Your Ref: LU/121/17/RES

Our Ref: NW/ARU/17/17/B

RE.Land North of Toddington Lane Parcel C1 and part Parcels B2 B4 and C2 Littlehampton BN17 7PP

Thank you for your correspondence of 20th September 2017 advising me of Approval of reserved matters following outline consent LU/47/11/ for construction of 126 No. dwellings together with internal road network, car parking & landscaping for which you seek advice from a crime prevention viewpoint.

Drawing Title:	Site Layout - INFORMATION
Drawing Status:	SUBMITTED
Drawn:	KJ
Rev:	-

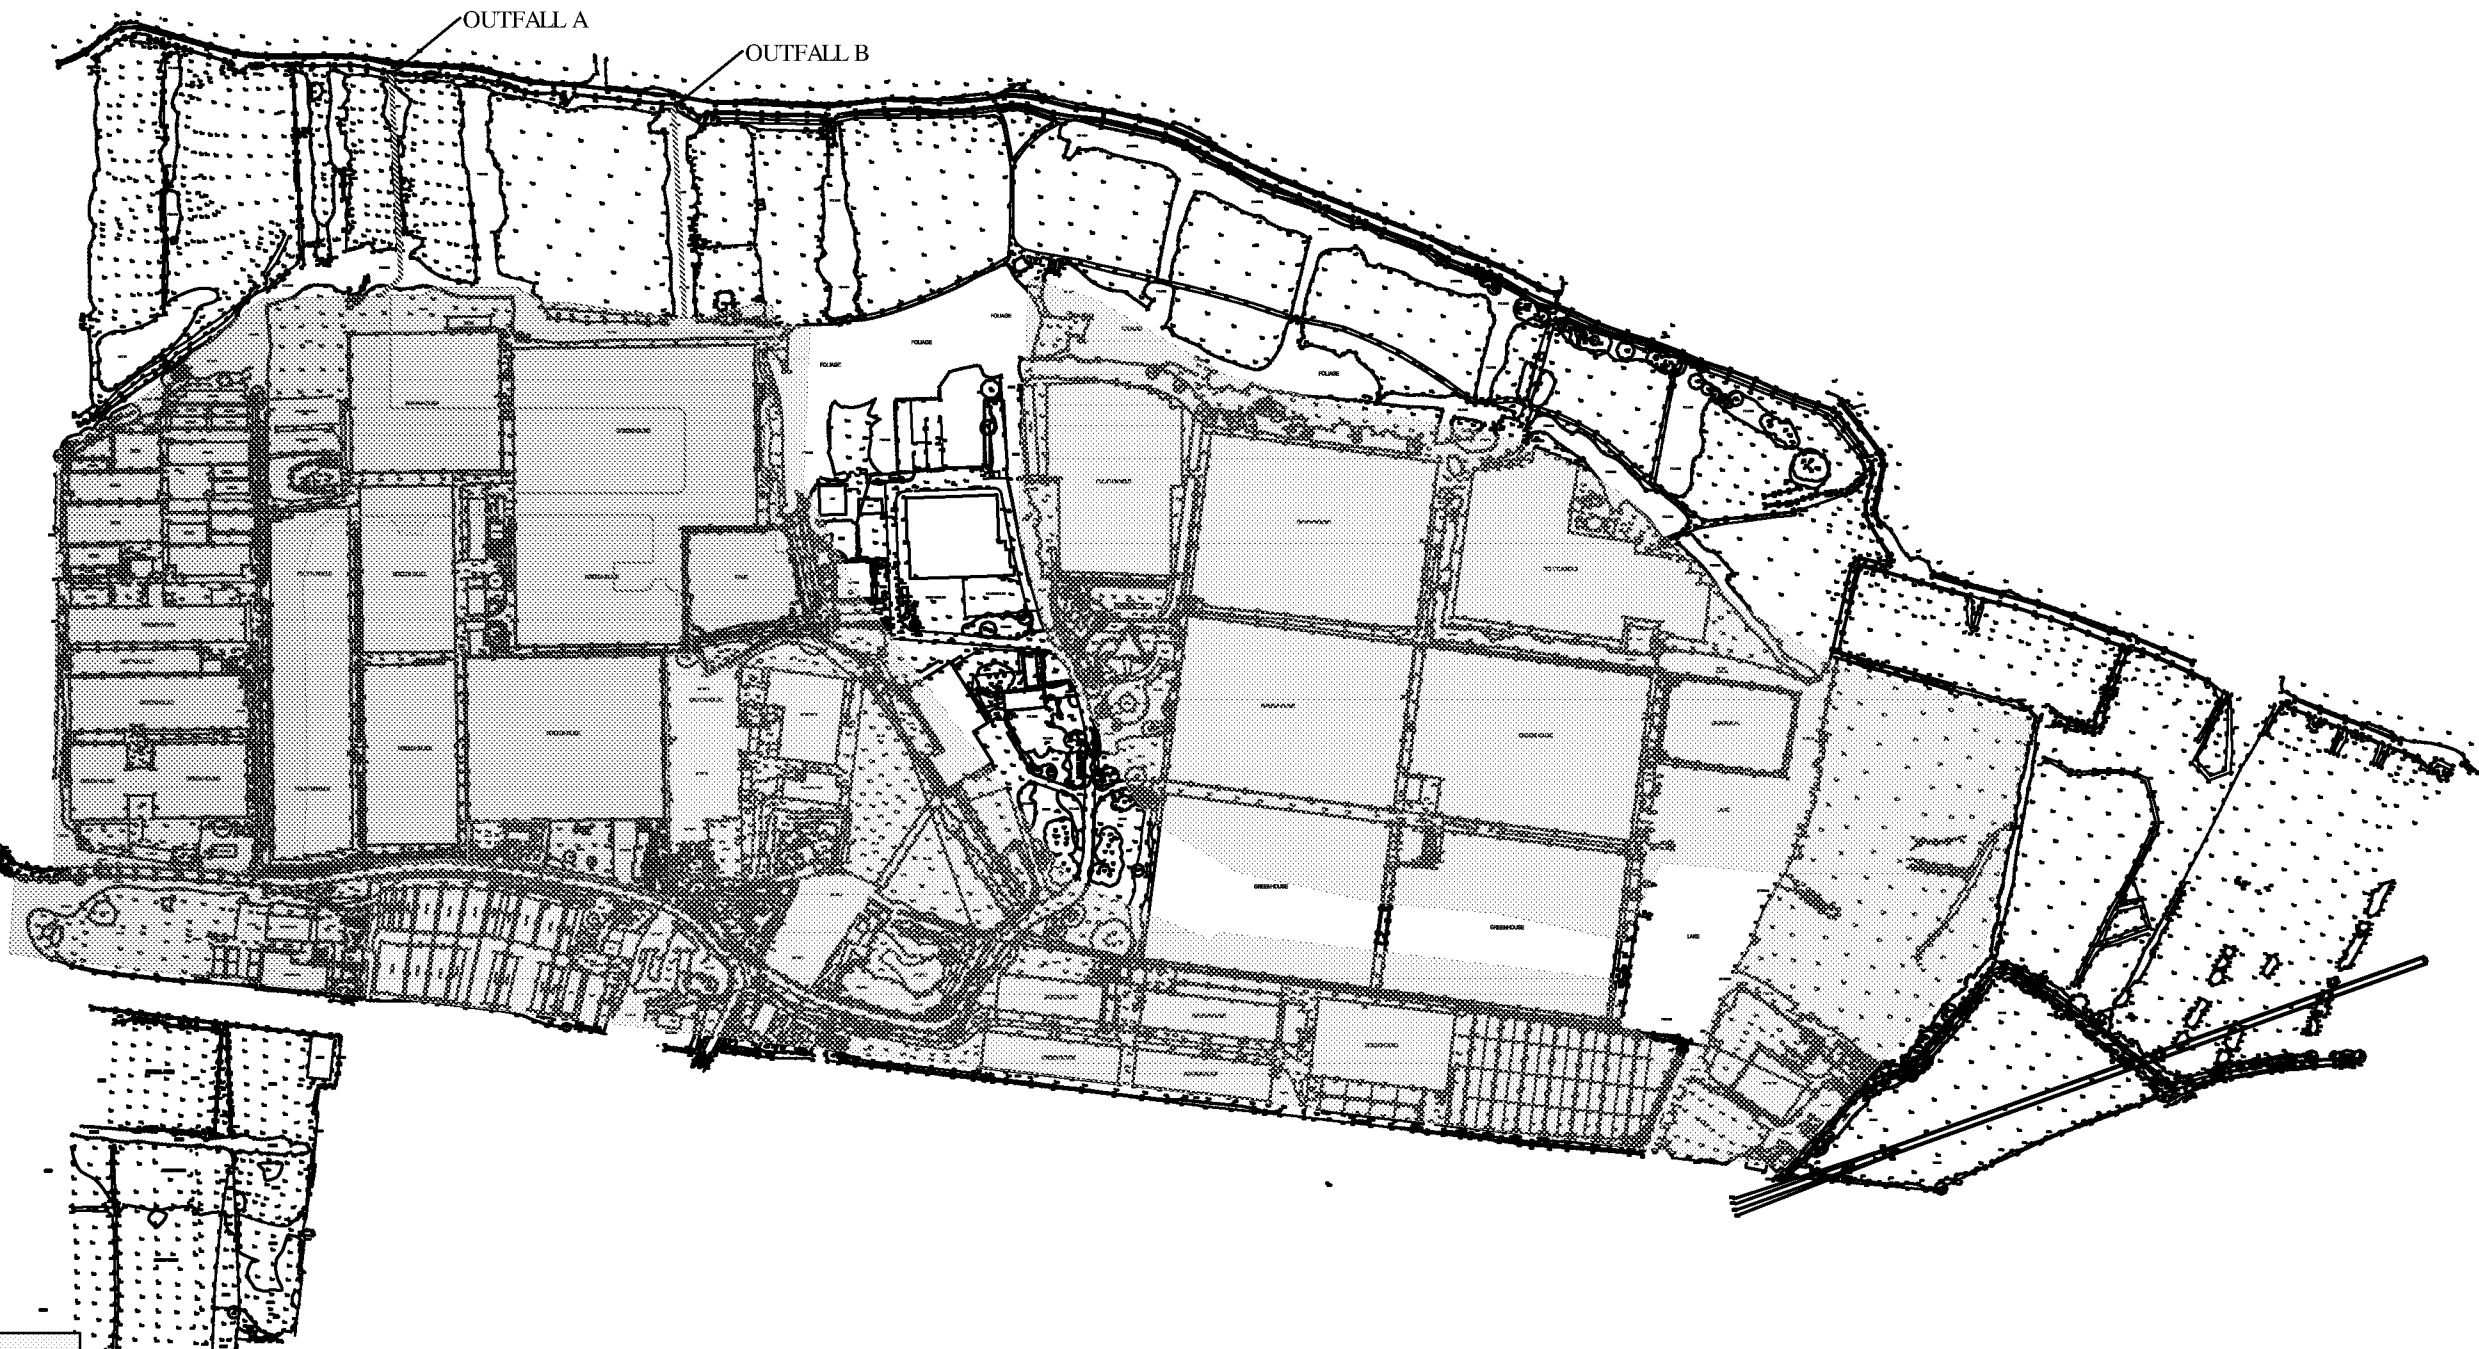
1. Parking bays for plots 101 and 65 and 55 are still an issue in that they are not overlooked by an active room.
2. Gates that provide access to the side of the dwelling or rear access to the gardens must be robustly constructed of timber, be the same height as the adjoining fence and be lockable from both sides. Such gates must be located on or as near to the front of the building line as possible. An example of this would be for plot's 5, between plots 7 – 8 & 9 – 10 and plot12. This will remove the opportunity for loitering and remove easy unauthorised access to the rear of the properties which otherwise would make it vulnerable.
